CITY OF ALBUQUERQUE

Re: Aztec Special Education Facility

Request 30-Day Temporary C.O. – Accepted Engineer's Stamp dated: 7/31/2015 (H20D033)

Certification dated: 1-18-17

CG-101

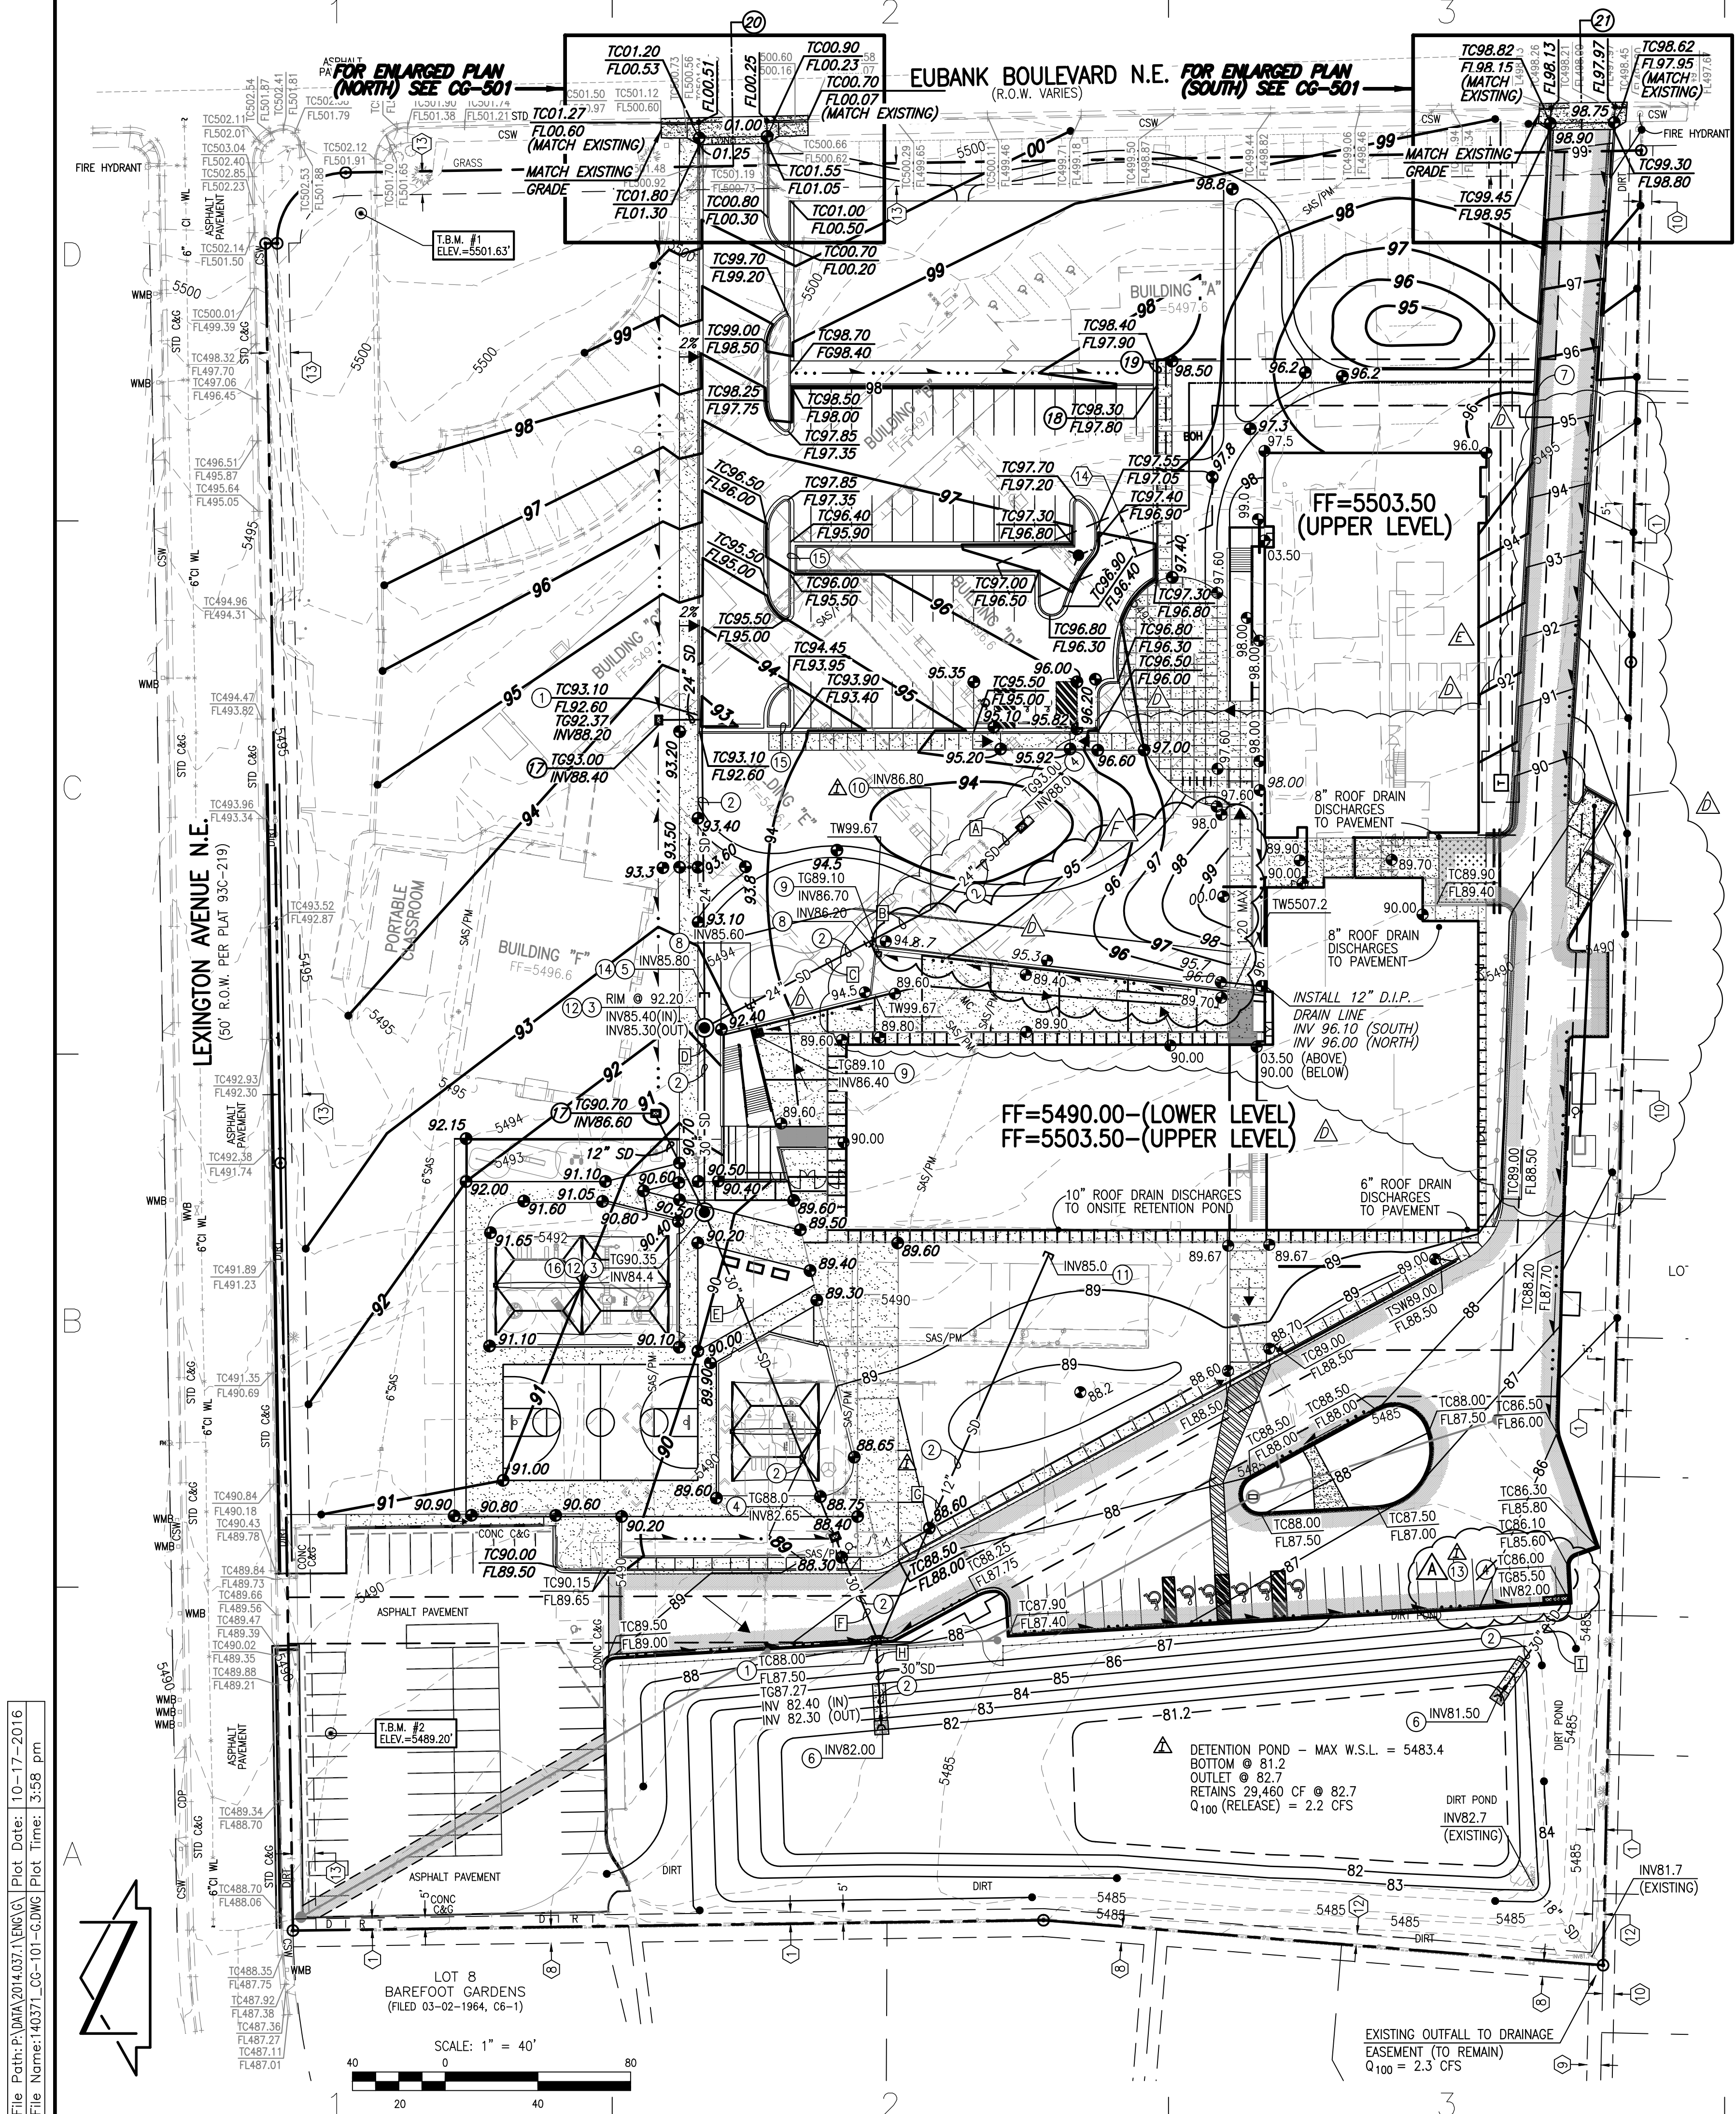
- Note #7 2' curb opening is missing.
- Submit approved engineer stamp drawings with stamp dates 7-31-15 and 8-31-15.
